DEVIATION REQUEST AND DECISION FORM

Low Flow Capacity

Project Name : Sterling Ranch Sand Creek Channel Construction Drawing Review CDR 20-4
 Schedule No.(s) : 5227301021, 5233309027, 5228000030 & 38, 5233301001 5233301016 & 17
 Legal Description : See Exhibit B – Legal Description

Typical Channel Cross Section

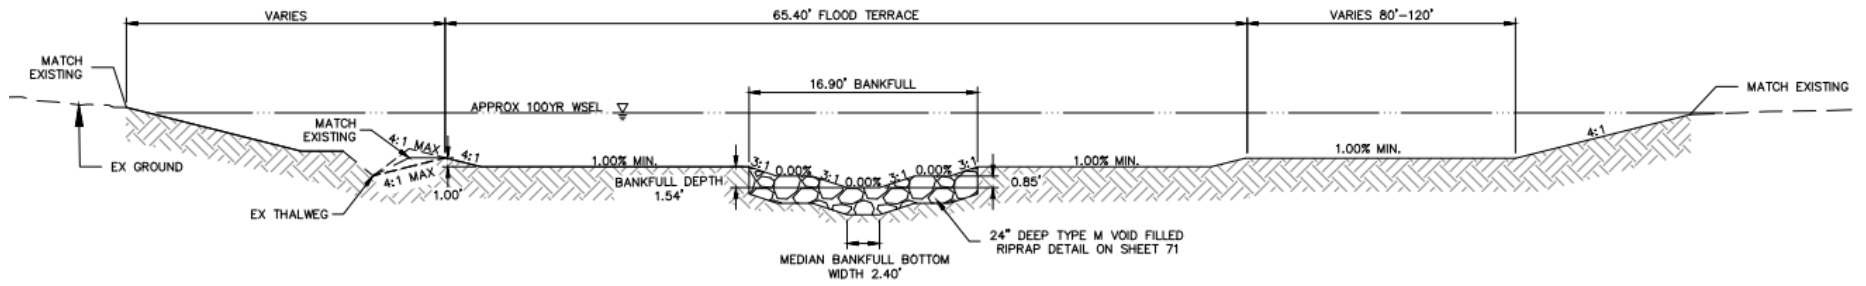
A deviation from the standards of or in Section **ECM section 3.3.3 Open Channel Design Standards** of the Engineering Criteria Manual (ECM) is requested for the Sand Creek Channel Design – Low Flow Channel Capacity.

Per ECM Section 3.3.3 Item B. All open channels shall conform to DCM Volume 1 and Volume 2. Per DCM Vol. 1 chapter 6.5 Open Channel Design Criteria, Section 3 Channel Cross Sections, the Low Flow Channel shall generally be designed to convey 10% of the 100 year storm or approximately 180 cfs.

The geomorphology study recommended a much smaller “low flow” channel section.

See Exhibit A for a representation of the “geomorphologist recommended” low flow channel cross section.

The proposed low flow channel in the Sterling Ranch Sand Creek design is approximately 16.9 feet wide and 1.54 feet deep and has a capacity of 29 cubic feet per second. The low flow channel is armored with 24” deep type M void filled rip rap.

The geomorphologist's reasoning for the smaller low flow channel cross section was that base flows in this reach of the channel are a fraction of the ECM criteria. Base flows in this portion of Sand Creek are a fraction of the required low flow capacity and the required low flow channel would be far larger than necessary to deal with the base flows, eventually leading the channel to cut its own low flow section for base flows. By using a narrower multi-stage section within the bankfull, dense vegetation can establish itself, particularly along the inner berm. Instead of the bankfull being sized for the larger events, the flood terrace has been sized to convey the two year storm. The frequency that the flood terrace sees inundation will also allow for denser vegetation within the flood terrace extents. Since the bankfull will be carrying a smaller proportion of the larger events, the floodplain is wide enough to ensure that flow depth remains low outside of the flood terrace. Shear stresses in the overbanks are low enough that seeding and riparian plantings will be sufficient to withstand the high flow events, with only a few areas requiring more substantial treatment.

Maintenance of the low-flow channel shall be by the Sterling Ranch Metro District.

Full stabilization and vegetation density will be required prior to preliminary acceptance
